RE: Resubmittal of Site Plan-DFT_PR2019-002765_SP-2025-00003 | Comment Response Letter

The following memo provides responses to DFT staff comments for Target ABQ W Site Plan located at St. Joseph's Dr NW between Coors Blvd NW and Atrisco Dr NW on February 12th, 2024. Staff comments are in *italic* followed by the Applicant responses that are in **red and bold**.

LANDSCAPING

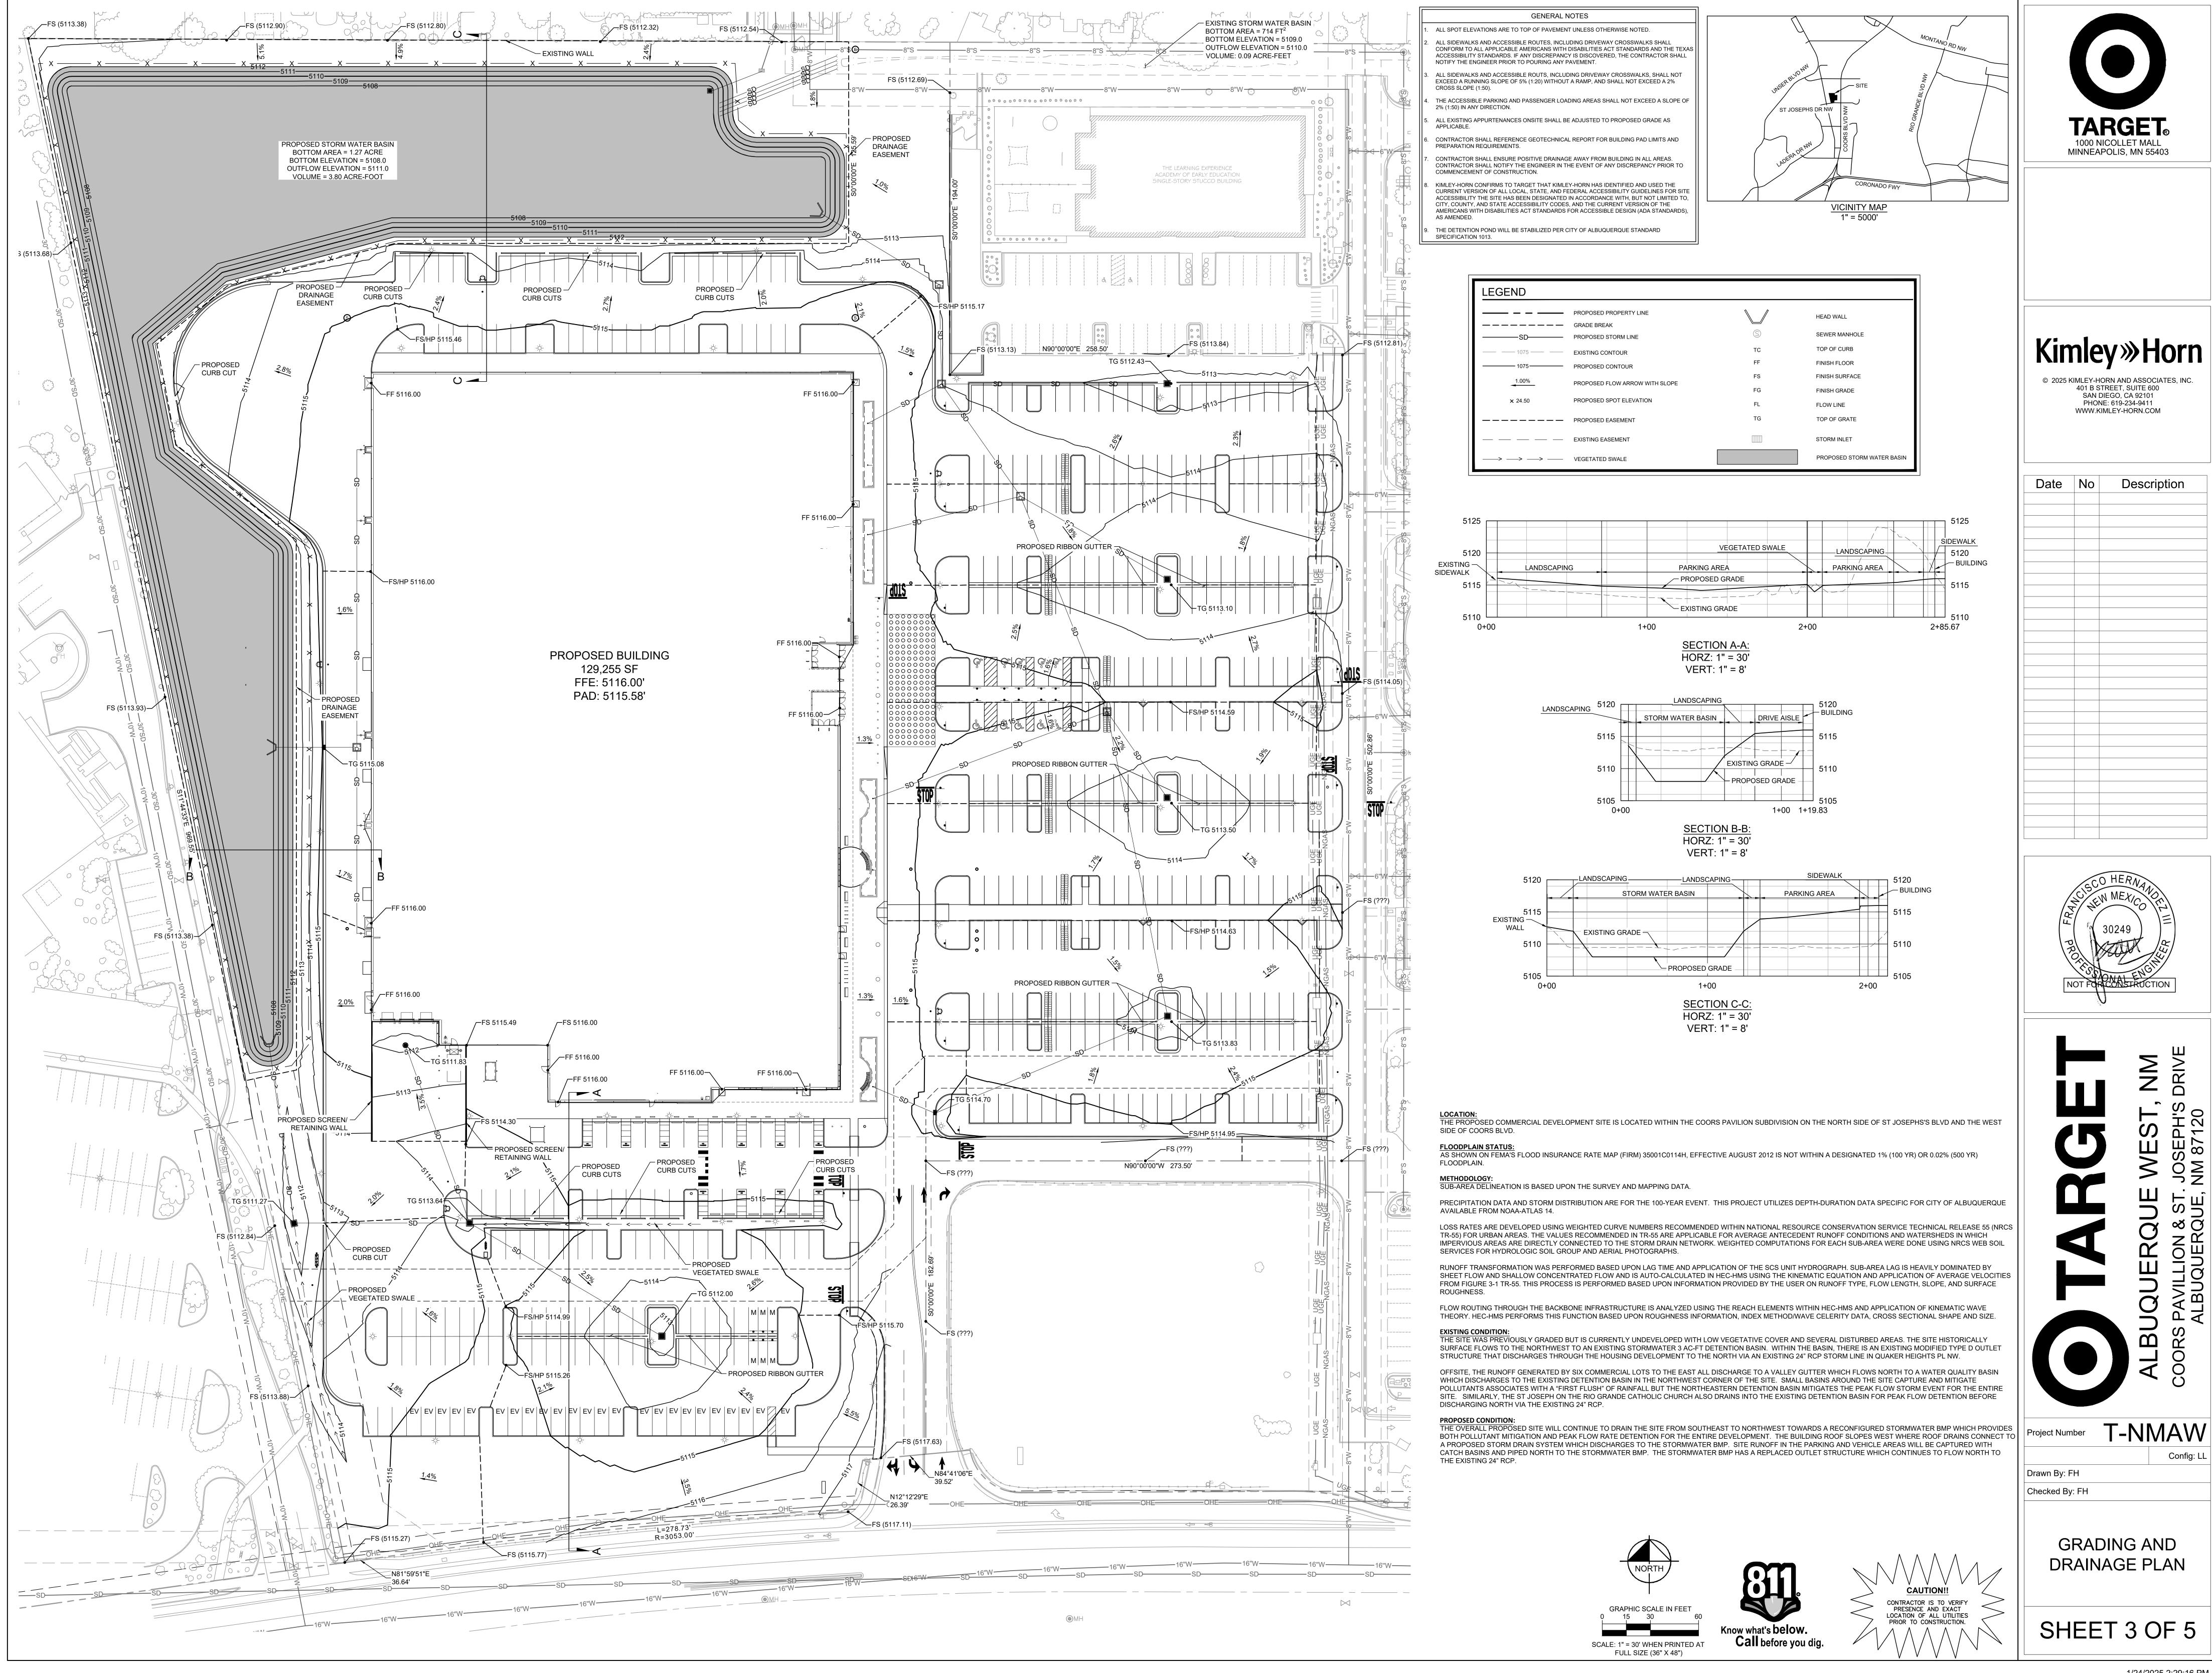
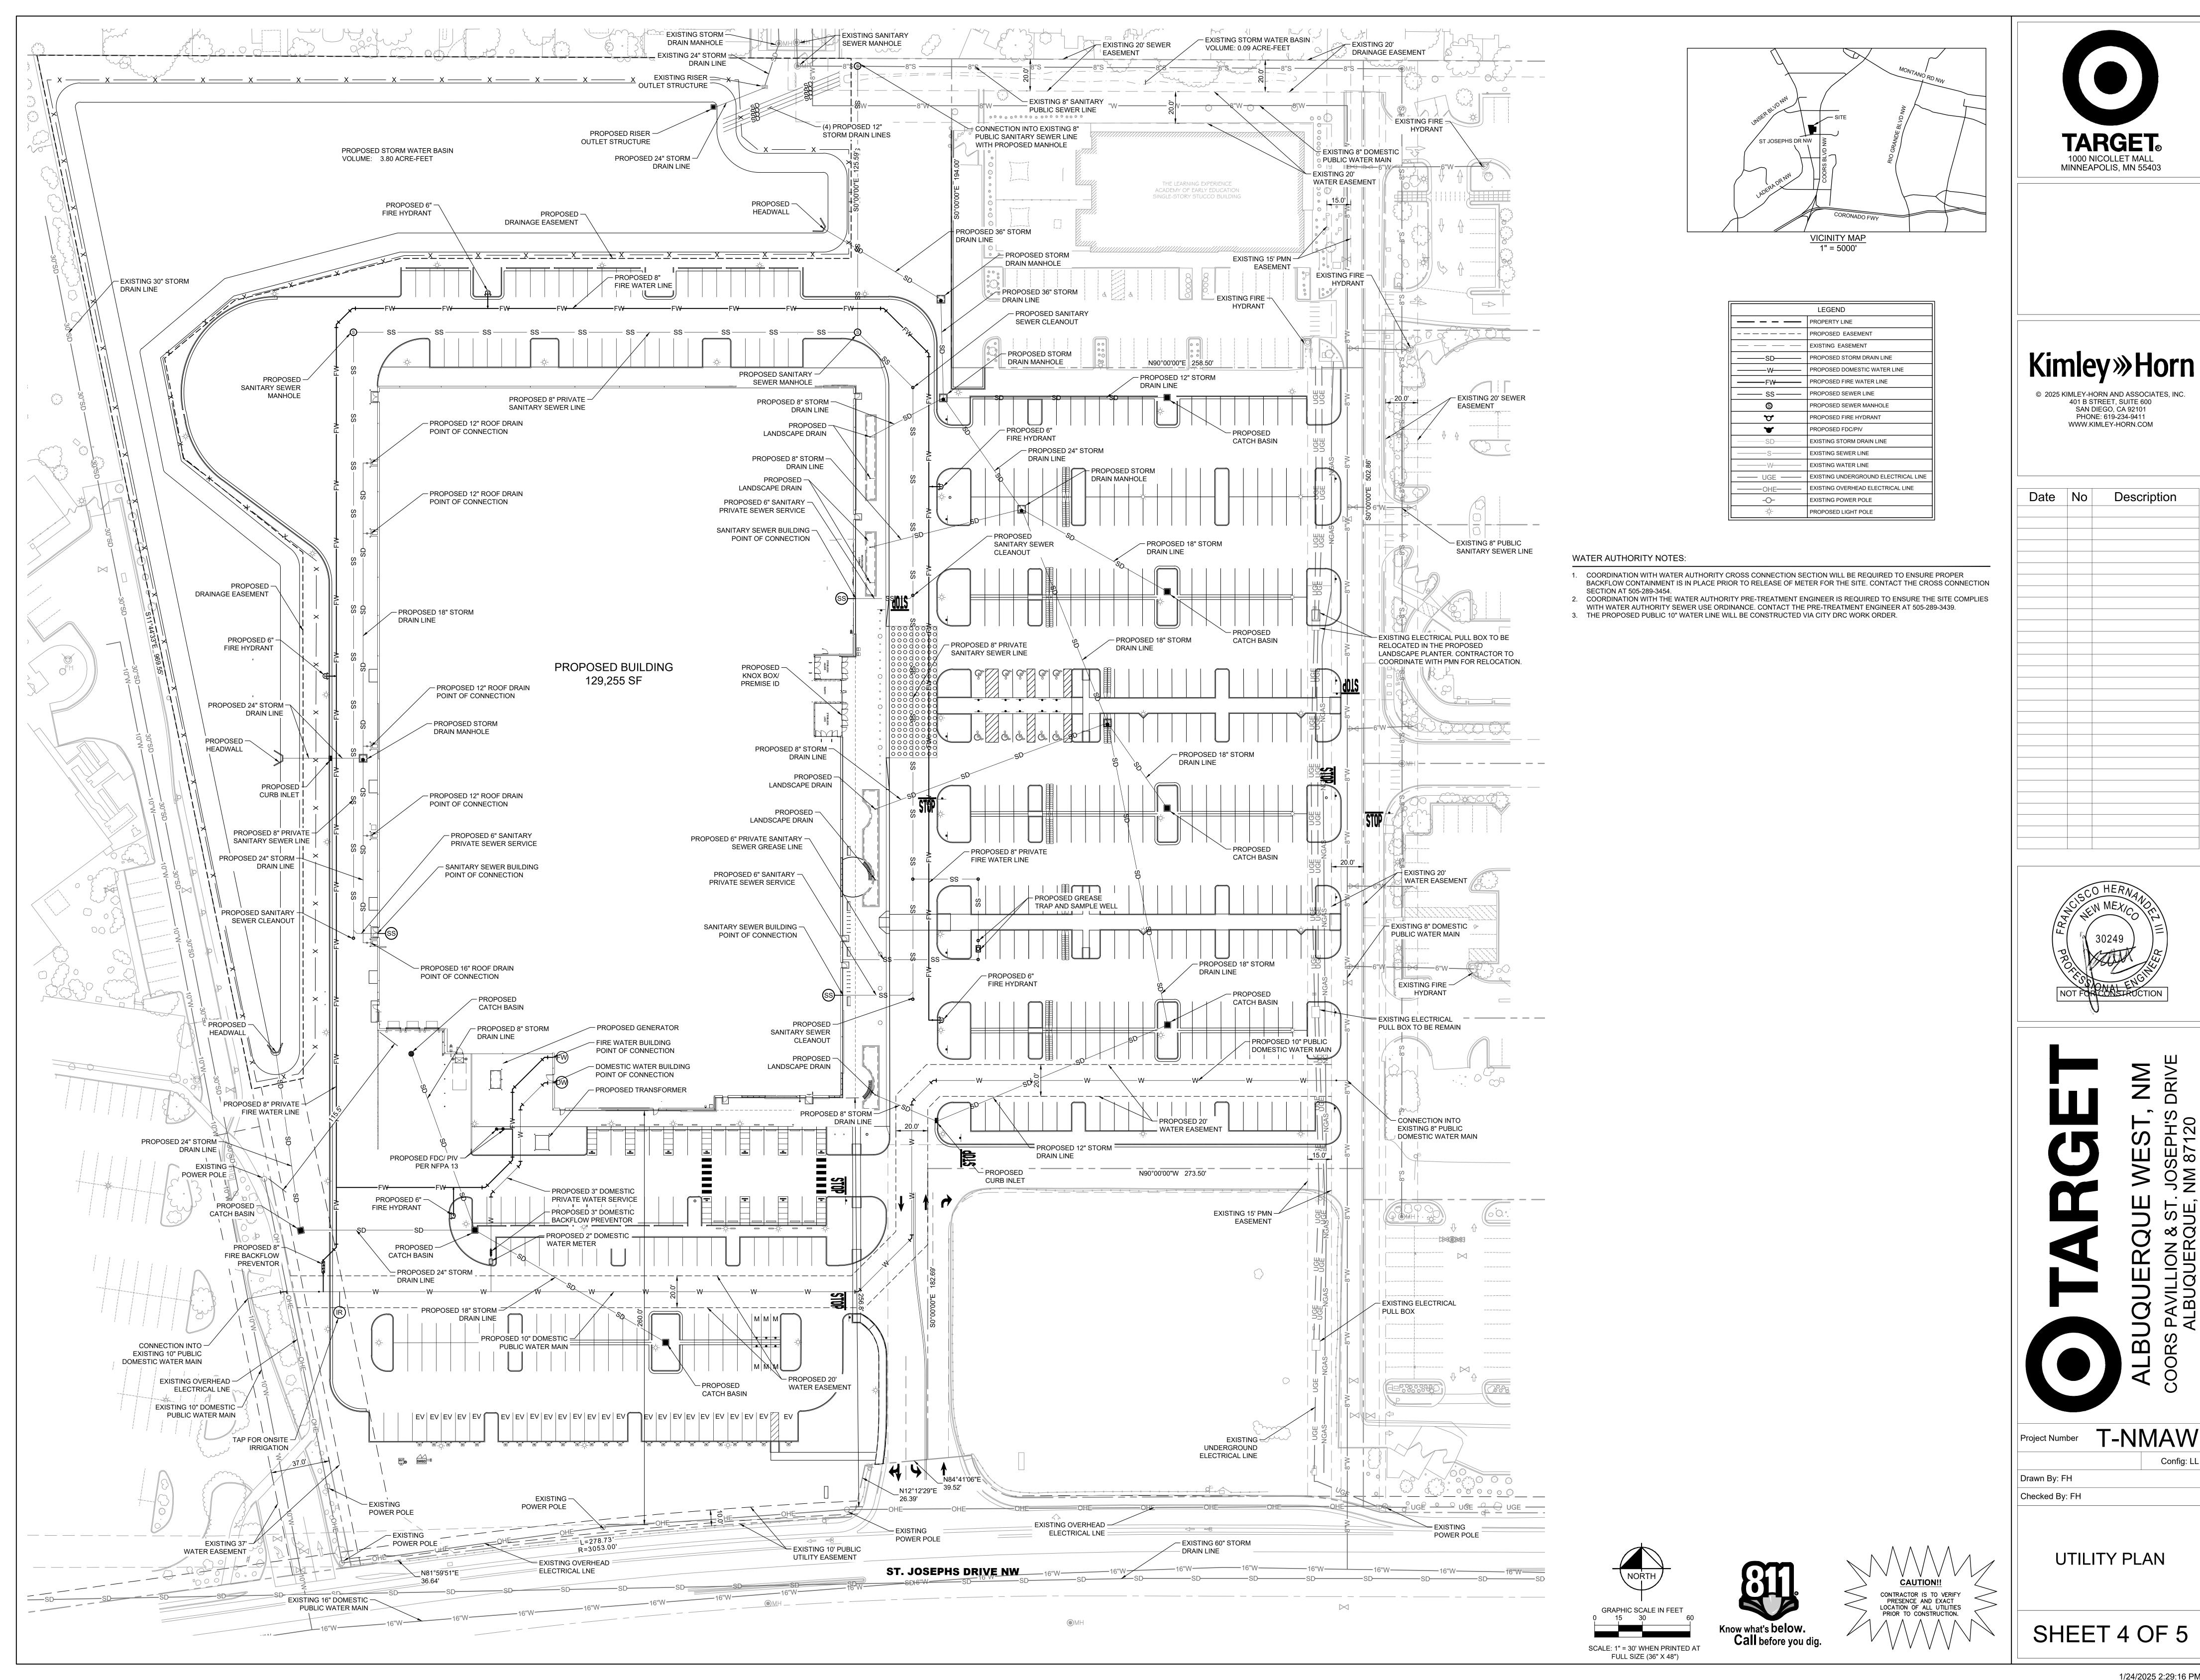
2. *Tree palette needs to be reviewed by City Forestry. For street trees and all other areas on the landscape plan use more than one type of tree and alternate the trees to avoid any future spread of disease among similar tree species.*

4. *Forestry will not accept Gambel Oak as a street tree as it does not meet the intent for street trees to provide shade. Please select a large deciduous shade tree for street tree requirements. Per IDO 5-6(C)(5)(e) Organic mulch is required as a ground cover under trees within a 5-foot radius around the tree trunk, but not directly against the tree trunk. In these areas, weed barrier fabric is prohibited. Please provide updated tree planting details showing these requirements have been met. (*Emailed comment from Hannah Aulick on 2/18/25*)*

a. minimum of 15 percent of the net lot area of each development shall contain landscaping. *Total required landscape area based on the net lot area must be added to the landscape plan.*

5-6(C)(5)(c) The use of gravel or crusher fines as ground cover is limited to a maximum of 75 percent of any landscaped area. *Calculations of total gravel mulch and total none gravel mulch needs to be added to the landscape plan.*

Applicant Response: Gambel Oak has been replaced with Chinquapin Oak (*Quercus muhlenbergii*) which is listed as a recommended deciduous tree in the City of Albuquerque Official Plant and Sizing List. Additionally, the tree planting detail has been revised to show organic mulch within a 5-foot radius around the tree trunk. See plans.

Applicant Response: Net lot area calculations and required landscape have been added to the Landscape Code Standards table on sheet 2A. See plans.

Applicant Response: Gravel mulch and non-gravel mulch area calculations have been added to the Landscape Code Standards table on sheet 2A. See plans.
